Our Ref: SLC/TT/257/545/2024DT2

McDonalds Monkwood Retail Park Elder Way Stevenage

The relocation of the approved internally illuminated freestanding totem sign

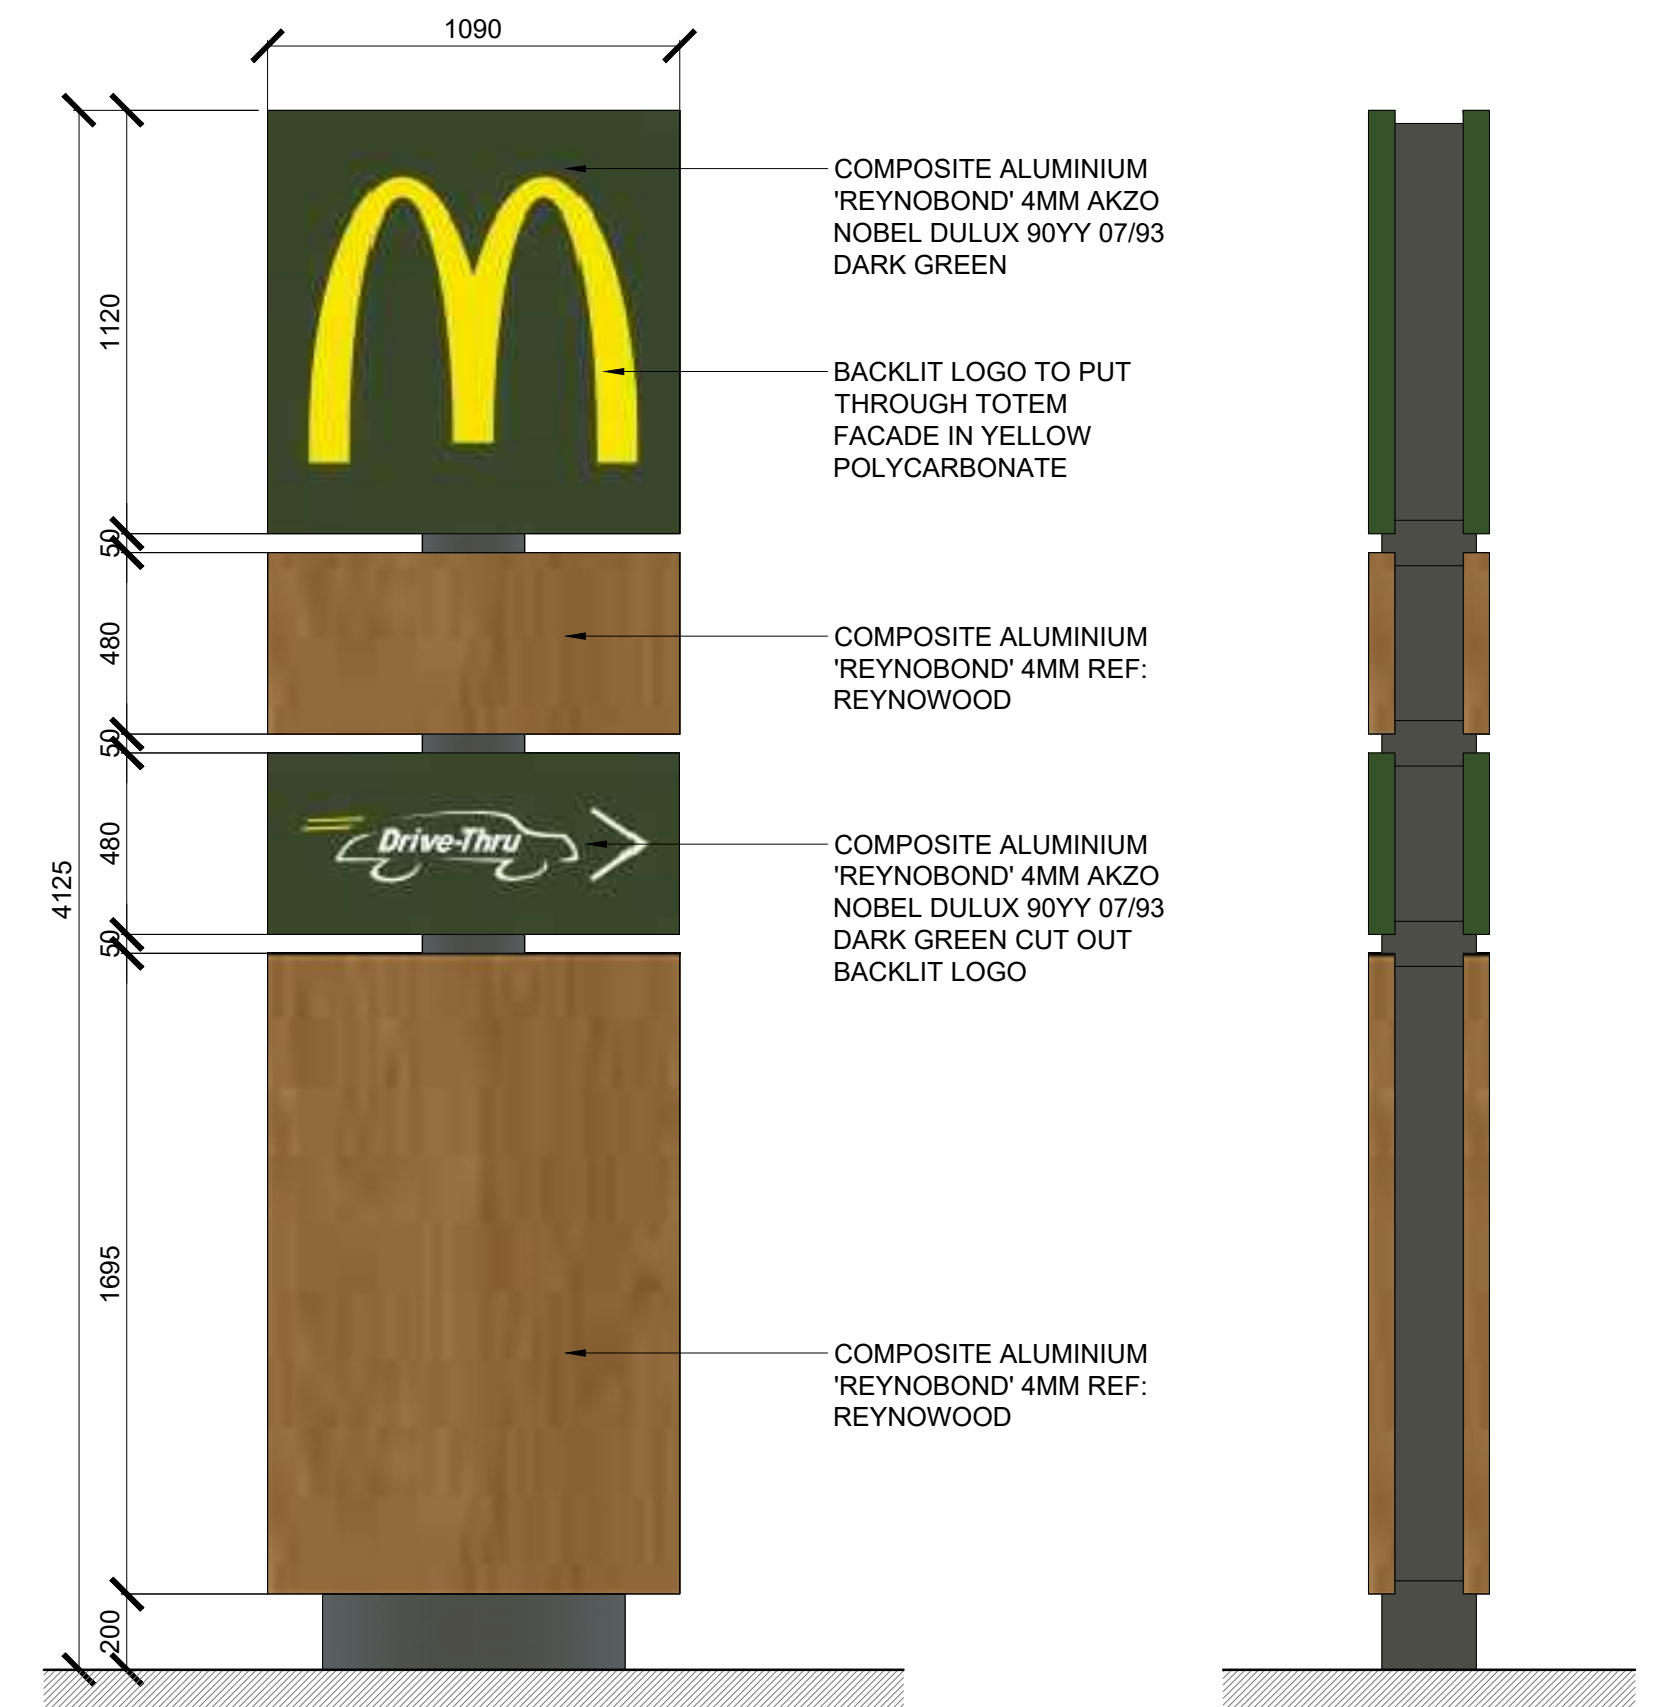
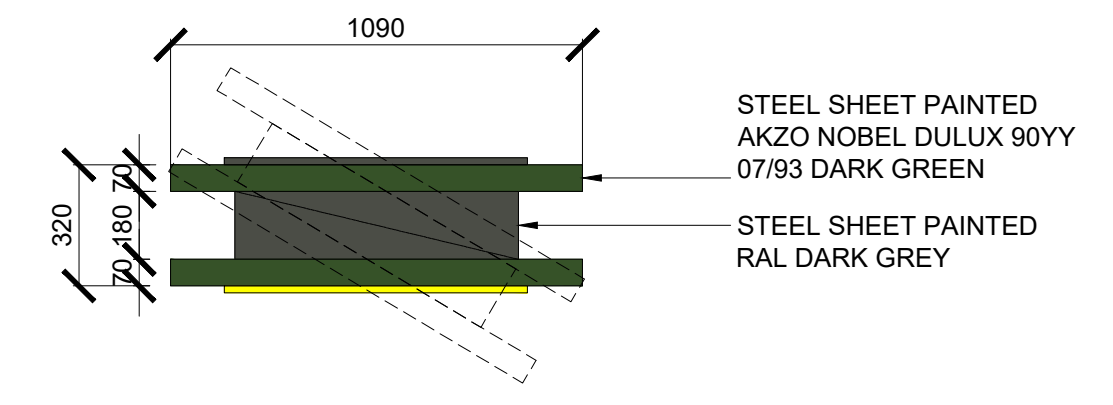
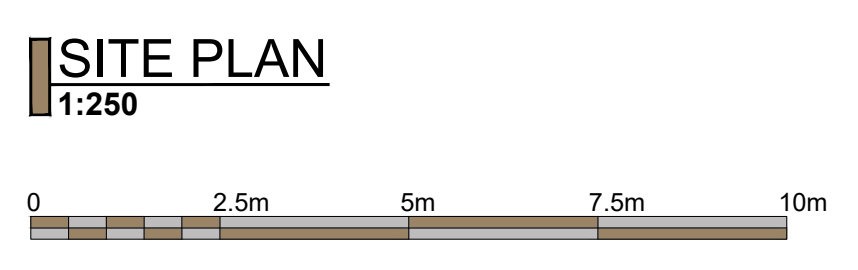
Please find attached an application for the relocation of the previously approved totem sign (Application Ref: 23/00379/AD). Prior to the installation and final surveys, it was noted that the position of the totem needed to be minimally relocated to ensure that the foundations did not impact on the existing infrastructure. There is no change in the size of totem and the revised location is 900mm further forward, as shown below:
